**Redevelopment and Expansion of Al-Faisal College, Liverpool (SSD-10445)
Response to Submissions**

Attachment A – Department's Key Issues

Redevelopment and Expansion of Al-Faisal College, Liverpool (SSD-10445)

OVERALL SITE PLAN

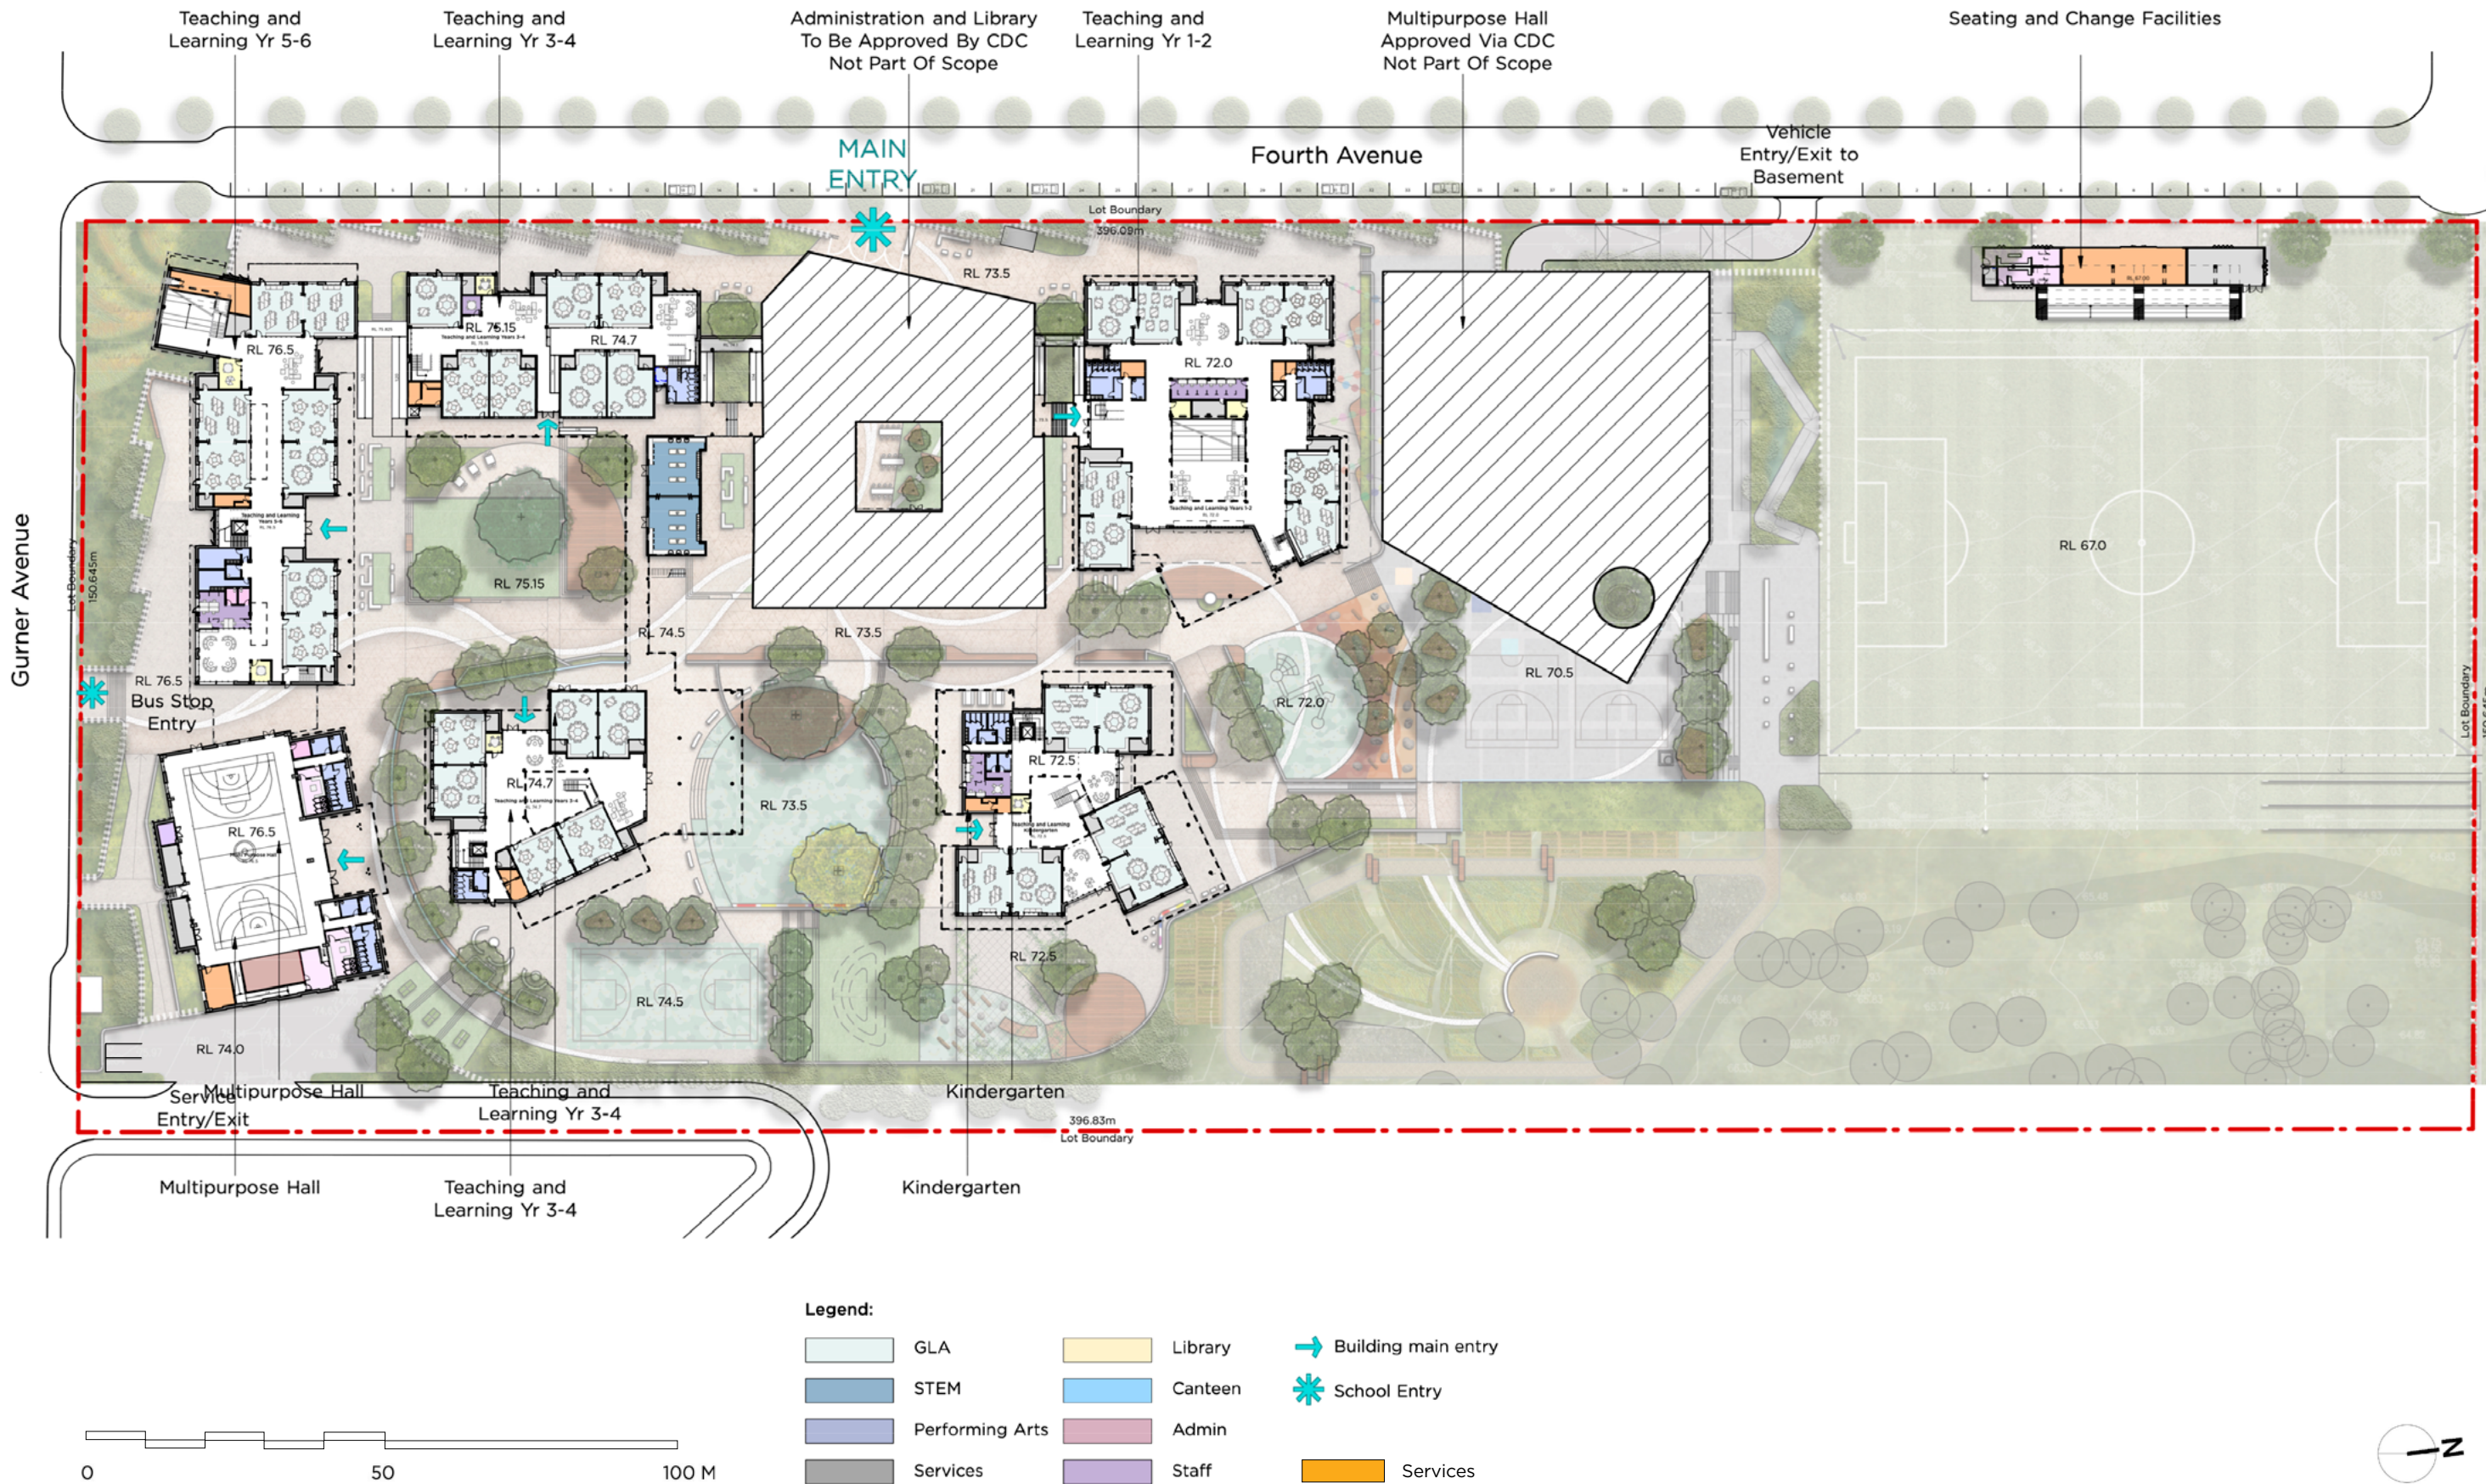
The Department requests the Applicant provide confirmation of those sites that they have landowner's consent to lodge the application. This includes the construction of roads and kiss-and-drop infrastructure, drainage infrastructure, tree plantings, landscaping and any other associated physical works upon which the application relies.

In particular, the Department notes that the vehicle entry/egress to the basement carpark and kiss-and-drop area for the primary school is proposed via Fourth Avenue, which is land that is owned and reserved only for TransGrid and Endeavour Energy access and infrastructure. The Department has been advised that consent to lodge the development application has not been granted.

Signage A - Perspective

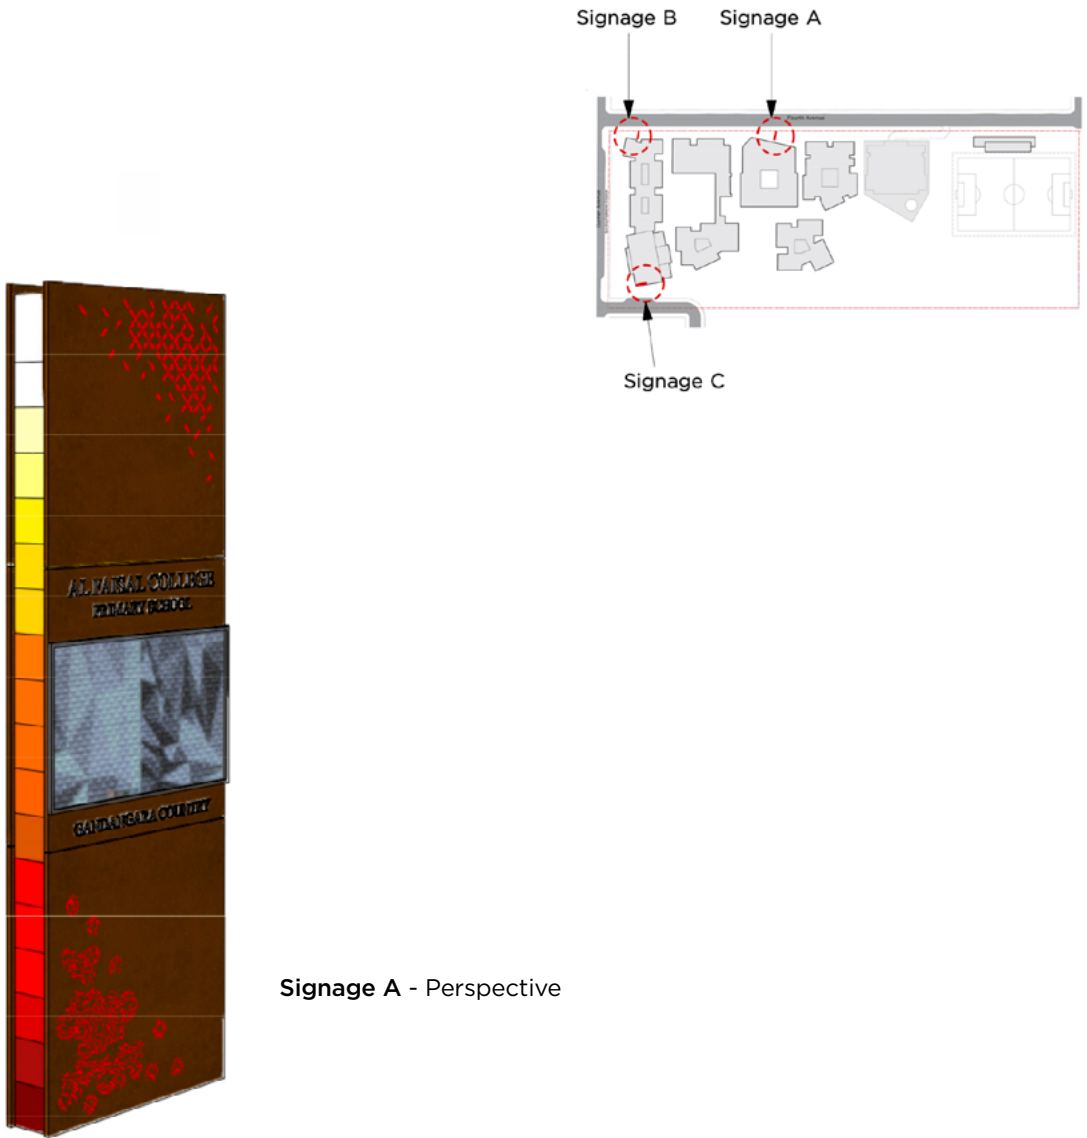
The Department raises concern in regard to the size and scale of the signage structures identified as 'Signage A' (primary school site) and 'Signage D' (secondary school site) in the Design Analysis Report which are proposed to stand at a height of 7.5 metres and 10 metres, respectively. Each structure is also proposed to include a large, illuminated digital screen.

The Department considers the signs are inconsistent with the existing and desired future character of the local area and do not comply with the Assessment Criteria under Schedule 1 of State Environmental Planning Policy No 64 – Advertising and Signage (SEPP 64). It is requested that the size and scale of the signage structures be reduced, and that the illuminated, digital screens be removed. All signage should be compatible with the surrounding residential locality and achieve consistency with the requirements of SEPP 64.
